ADC PARKS & GREENSPACE ARBORICULTURE CONSULTATION

PLANNING APPLICATION: AW/146/13/T

ADDRESS: Ditch to the rear of 23 Fernhurst Gardens Aldwick PO21 4BA

BRIEF DESCRIPTION: Reduce the crowns of 2 No Field Maple trees by 4 meters

SKETCH.

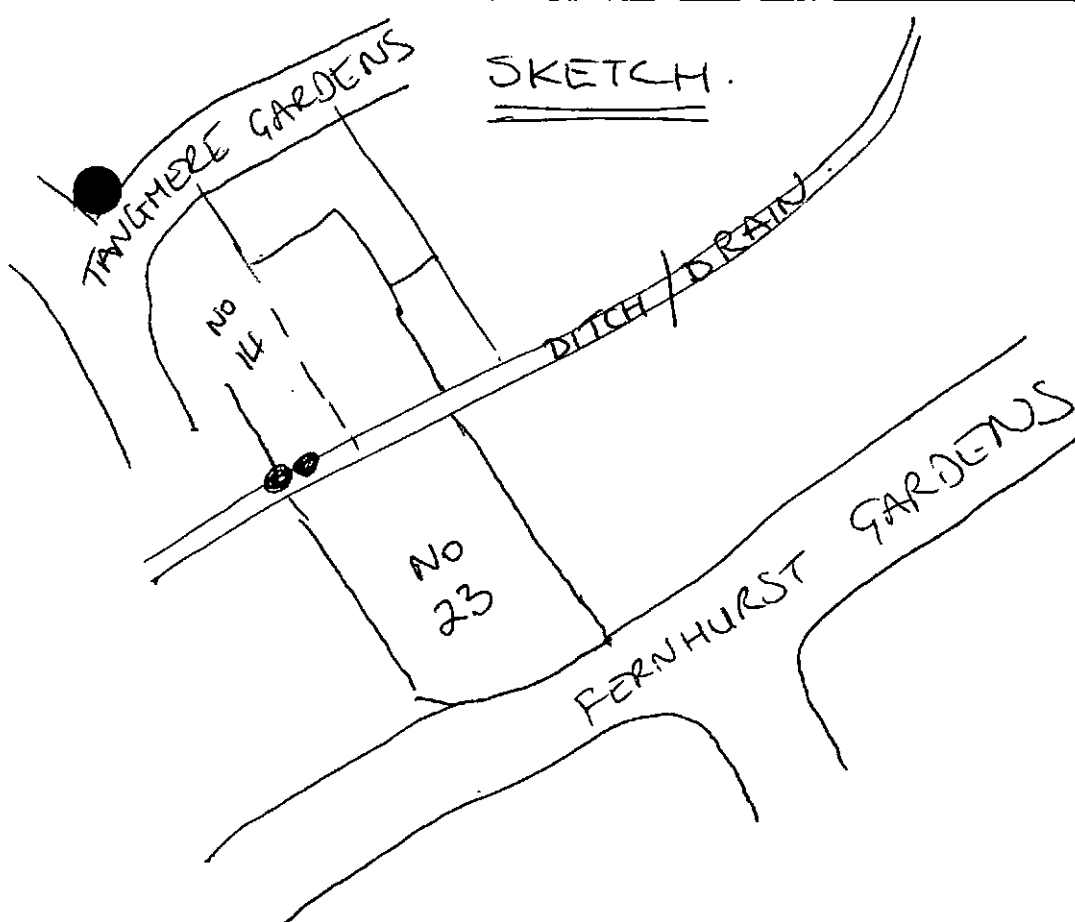
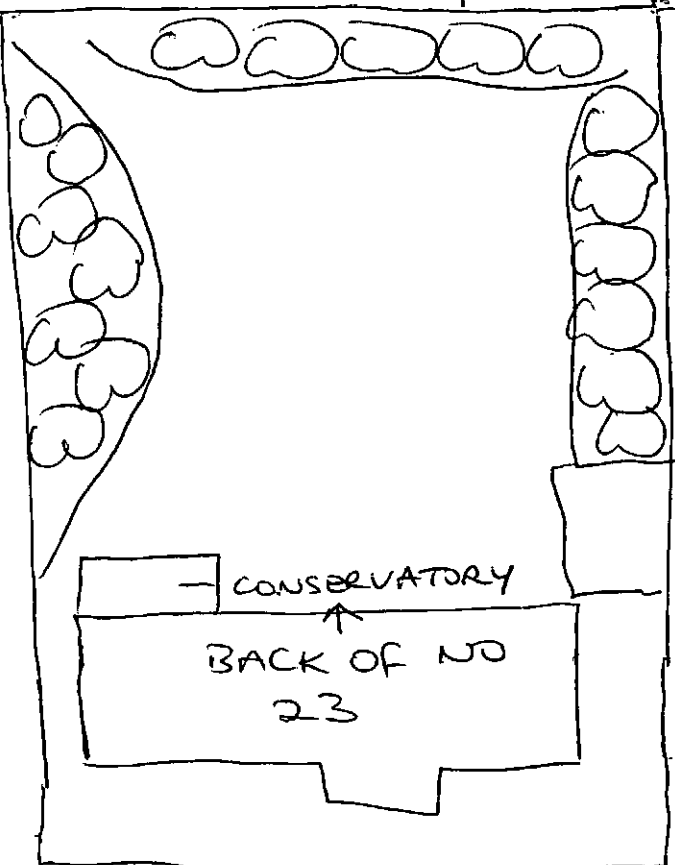
I have surveyed the two Field Maple trees and there is scope to reduce both. A lesser crown reduction is advisable as the proposed 4m could result in a stubby/abruptly cut appearance and be detrimental to their visual amenity. I have suggested Planning Conditions for the work which will help to prevent unnecessary loss of crown foliage and maintain some natural amenity.

- The crown reduction must not exceed the removal of 2.5m branches.
- Wound sizes should not exceed 50mm in diameter.
- All work should be carried out using a pruning saw for small diameter cuts (as above).
